From: [Mau, Russell E \(DOH\)](#)
To: [Zach Torrance-Smith](#)
Cc: [Melissa Schumaier](#)
Subject: Re: SP-26-00004 Moulton - Notice of Application
Date: Monday, June 15, 2026 9:43:27 AM

The Department of Health (DOH) Office of Drinking Water (ODW) has reviewed the application generating the following official comment:

Subject: SP-26-00004 Moulton - Notice of Application

MOULTON SHORT PLAT

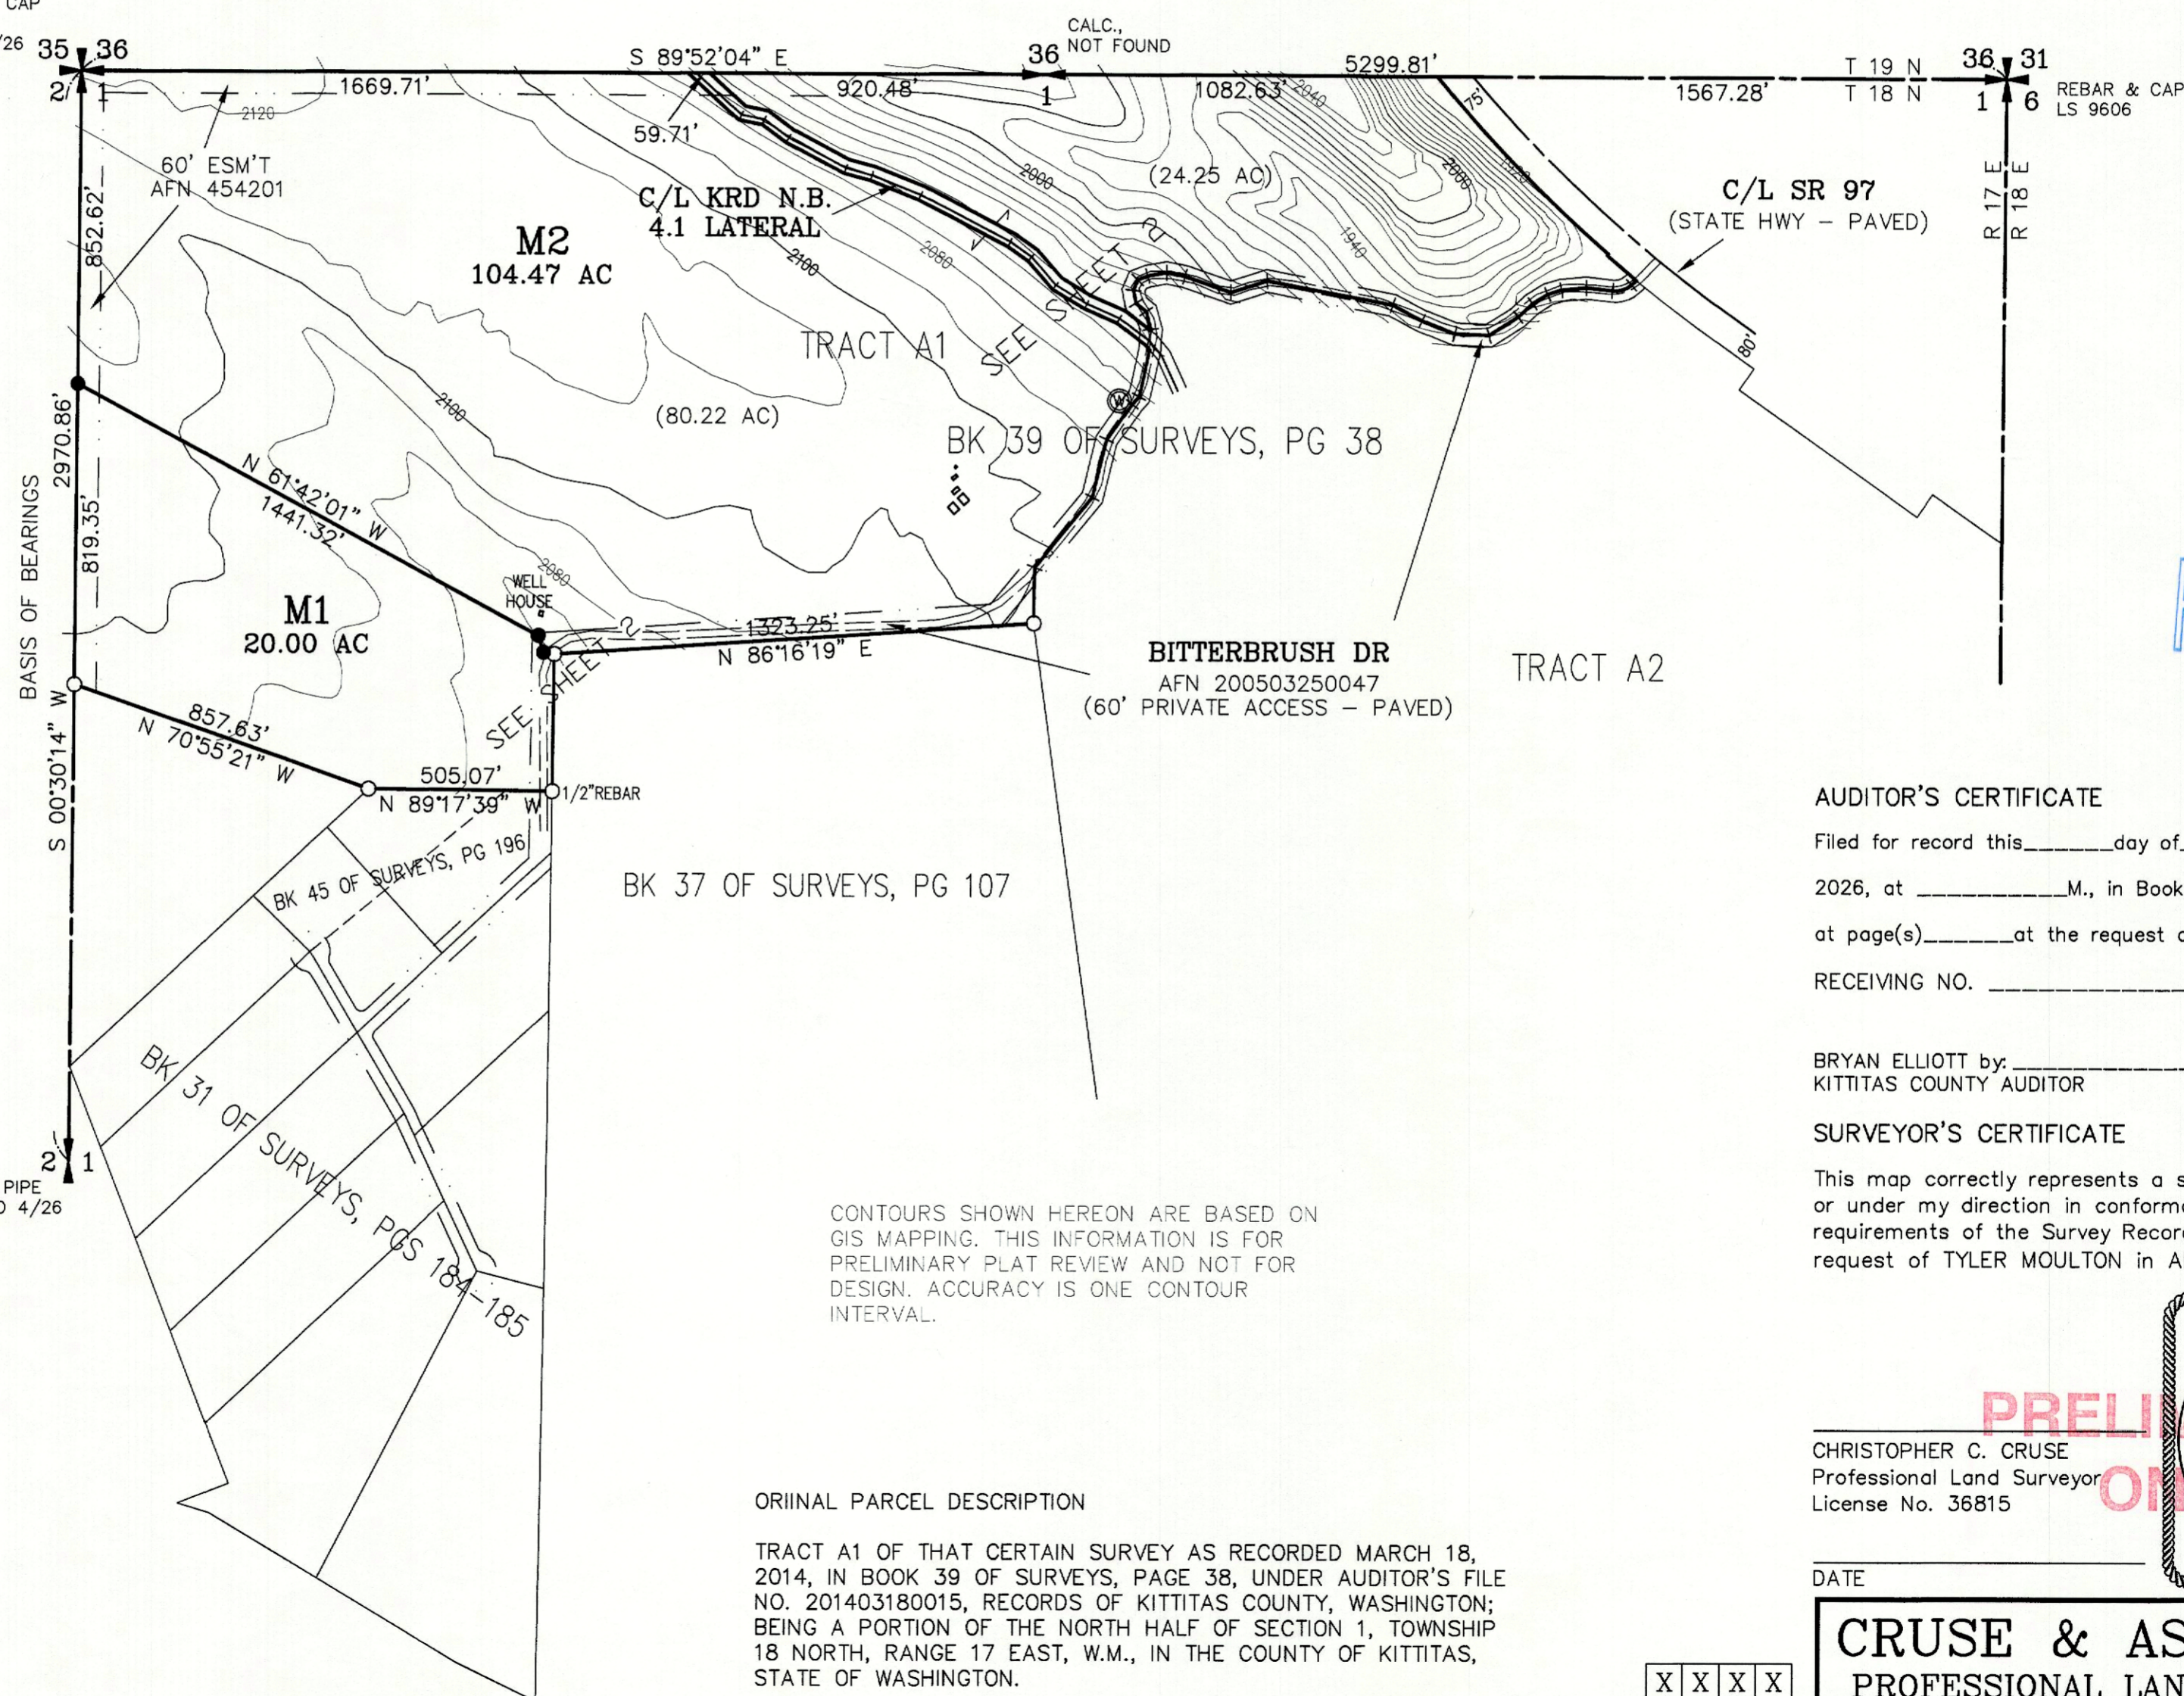
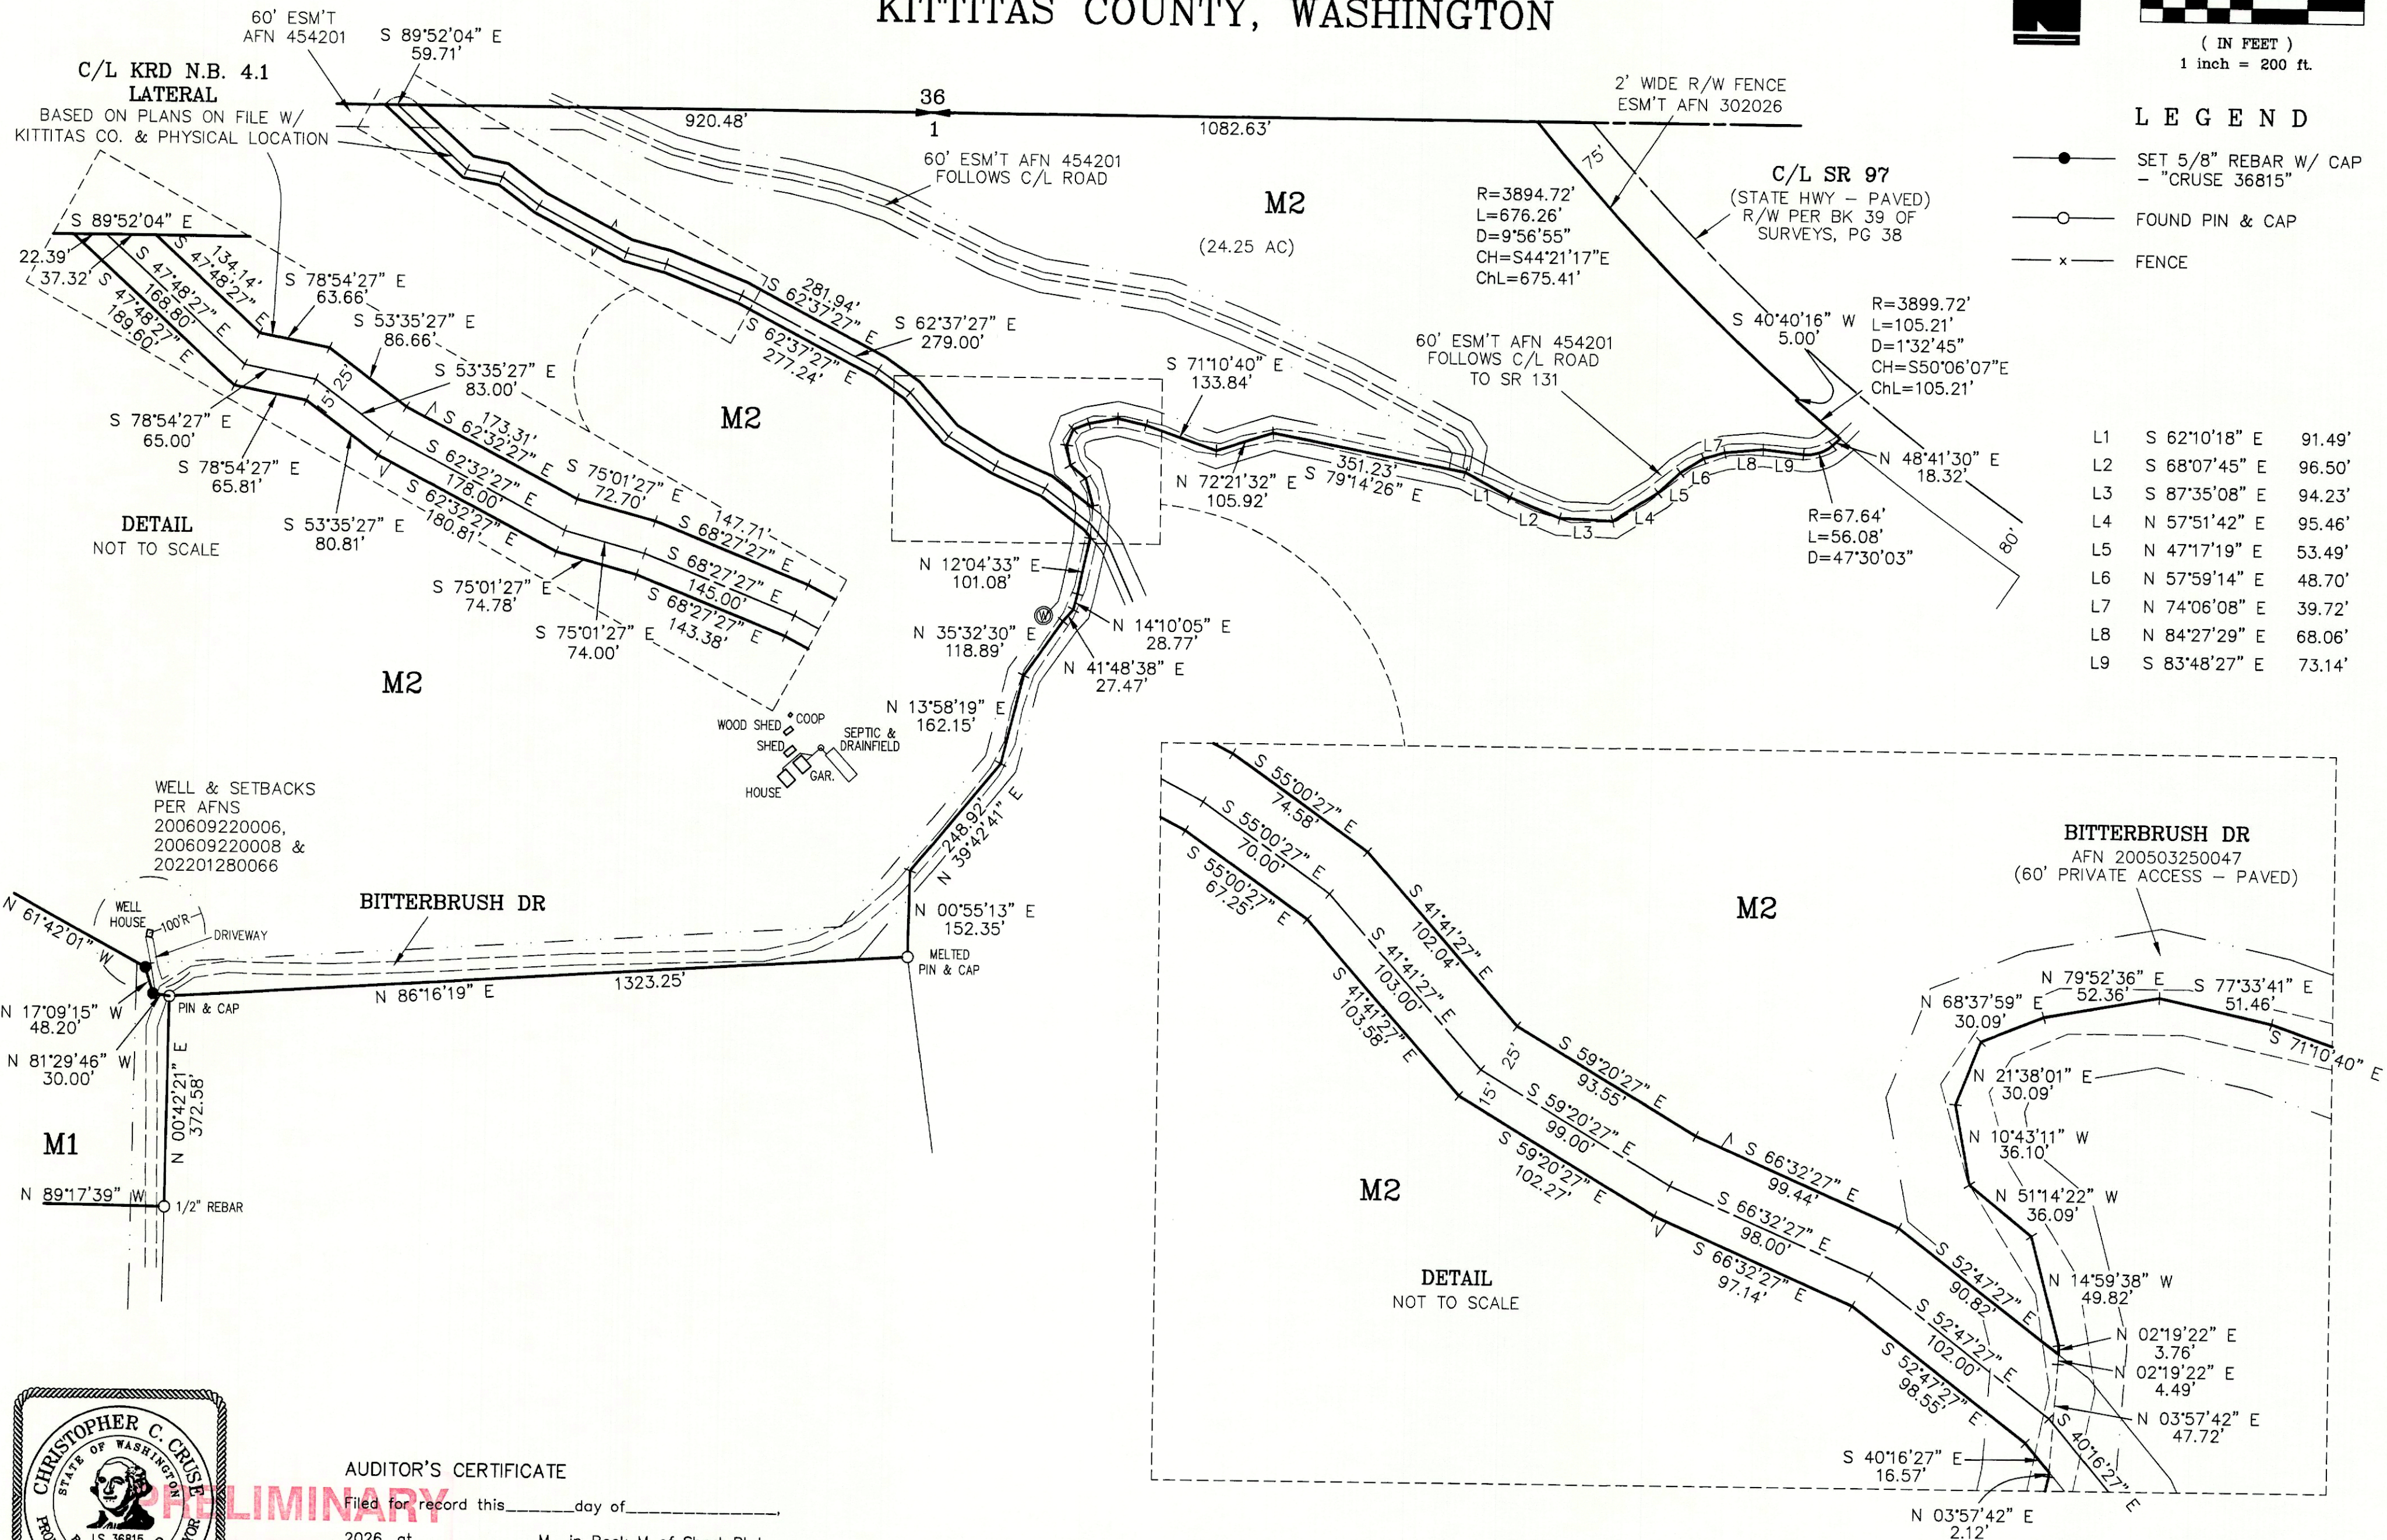
- The "Narrative" states water is "to be from a previously established community well" - DOH ODW is seeking the name and ID number for this water system.
